Rezoning Transportation Analysis

Petition Number: 2020-083

General Location Identifier: Tax ID 12703702

RZ-02

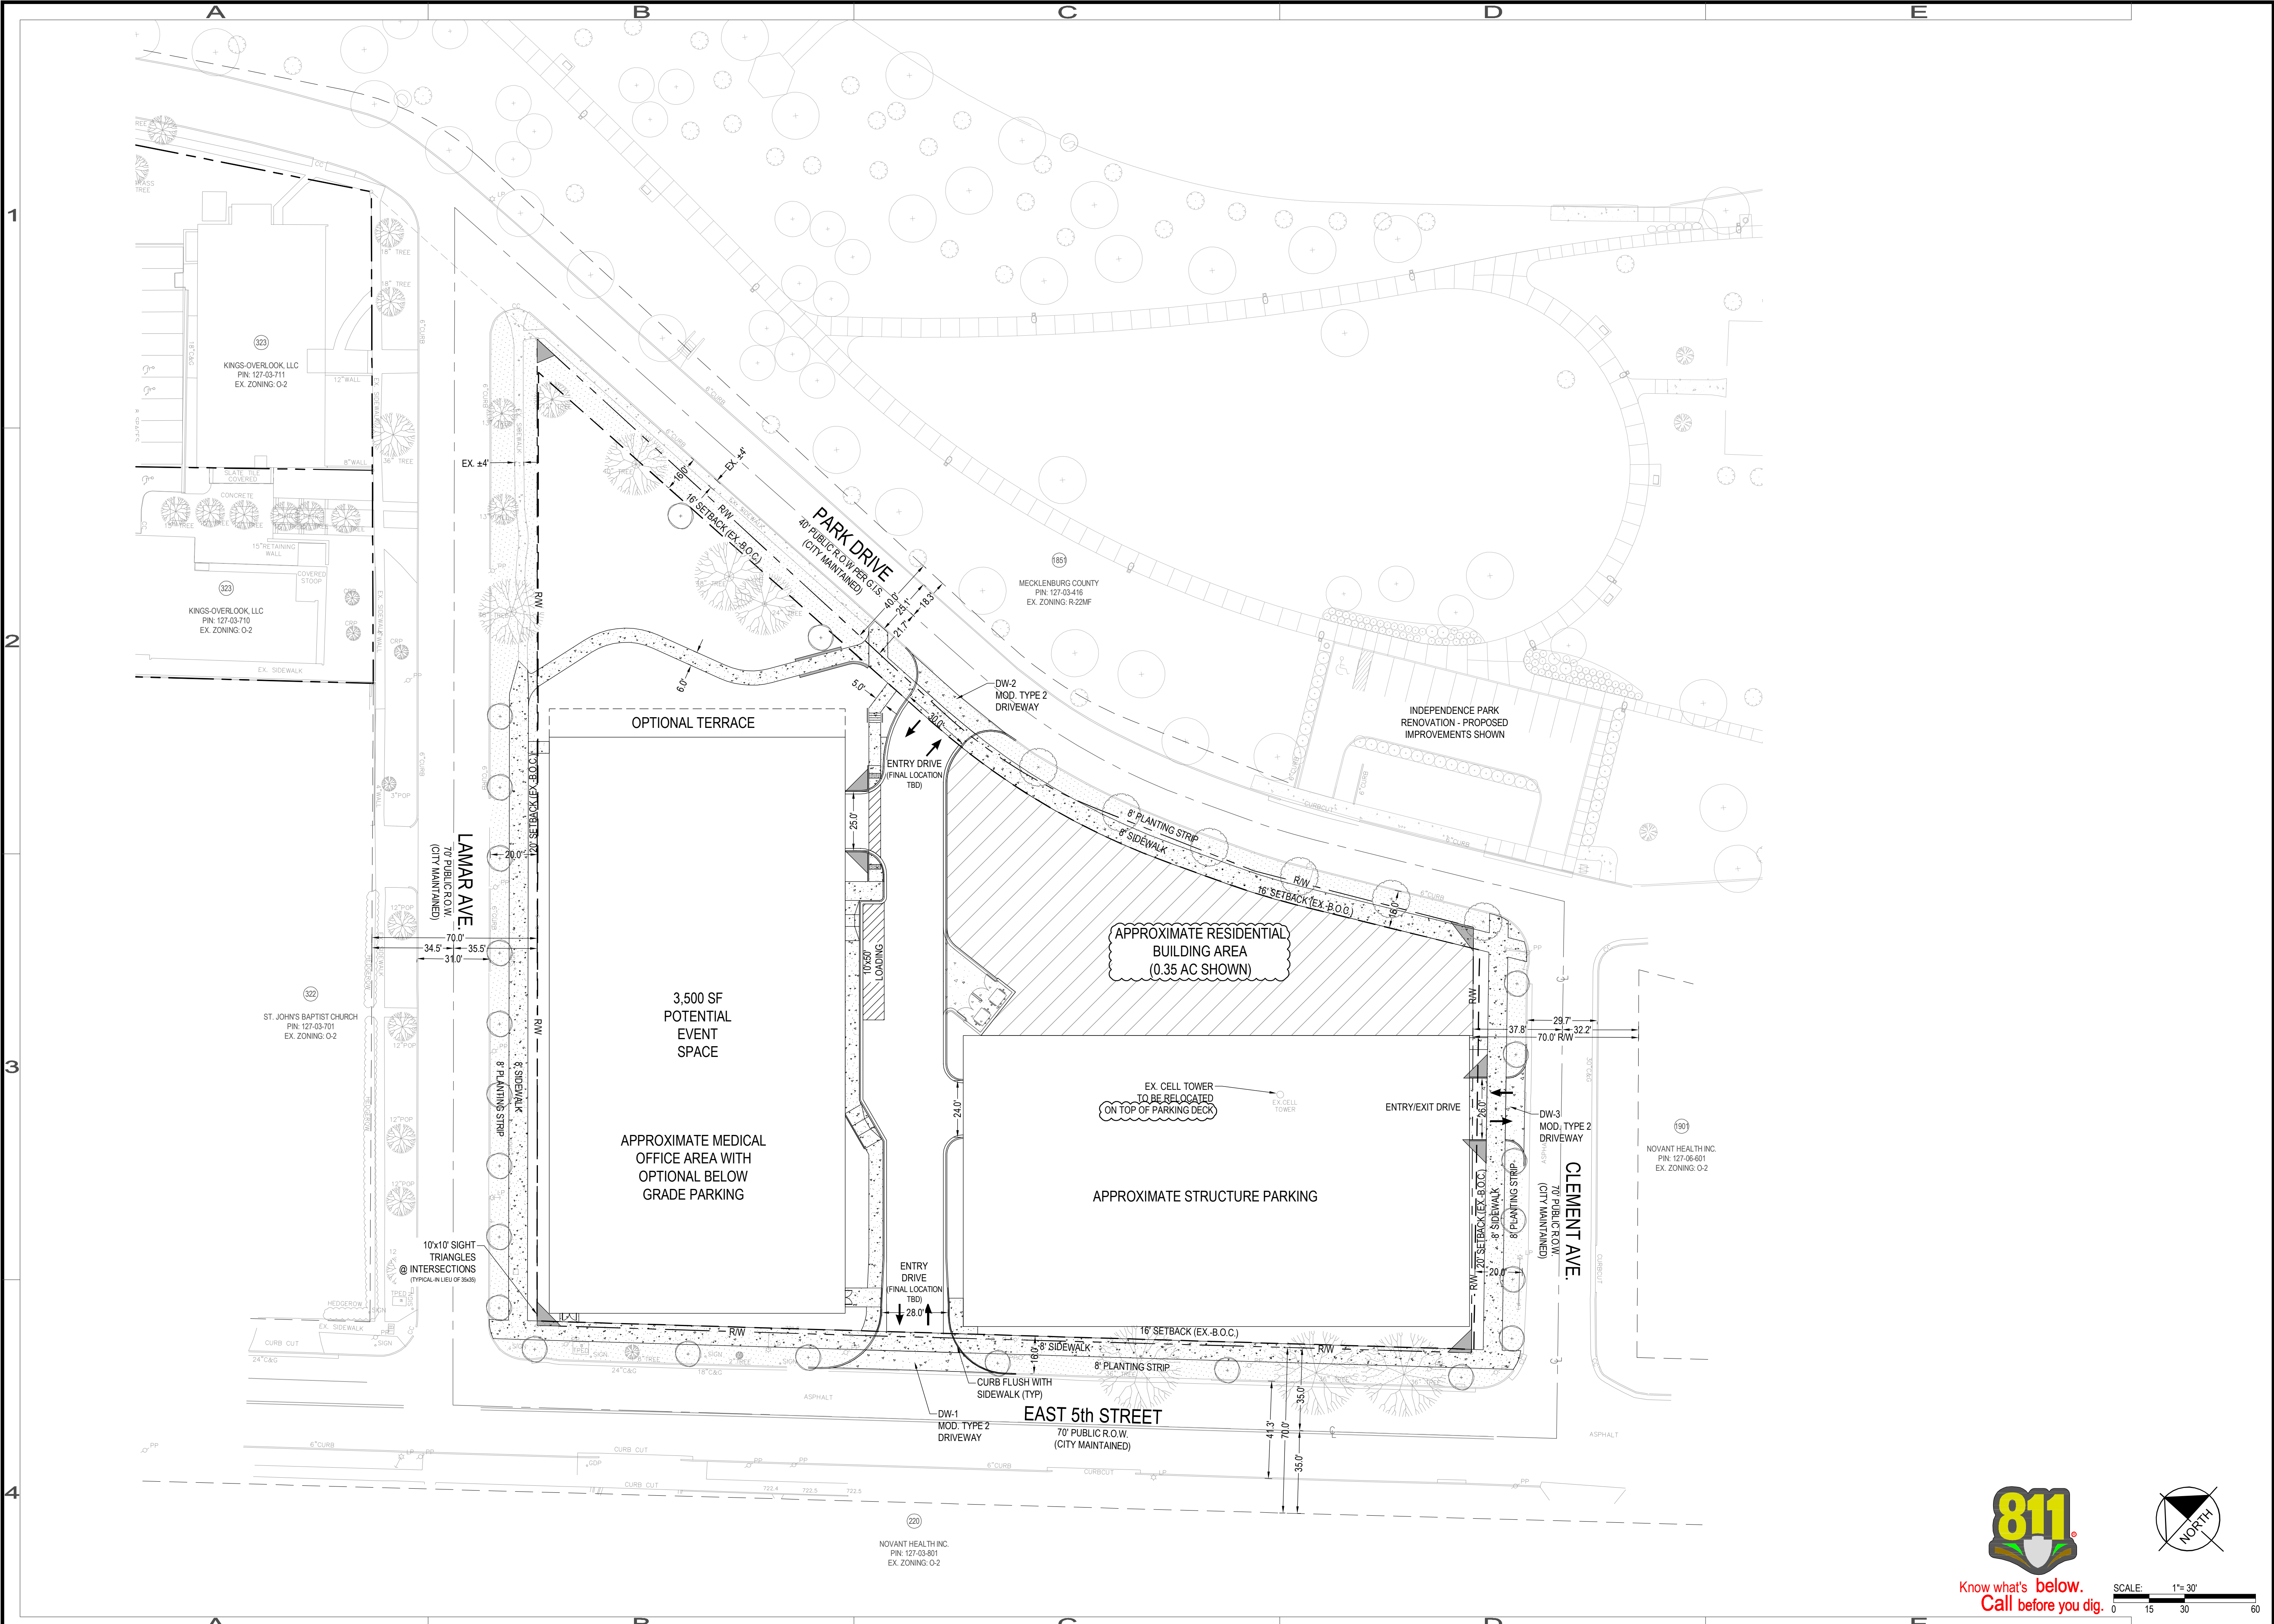
The site plan should show the curb and gutter labeled and dimensioned from the centerline for each road.

4. ~~The petitioner should revise the site plan to show the driveway further away from Clement Avenue — a minimum of 75' from the Clement Avenue.~~
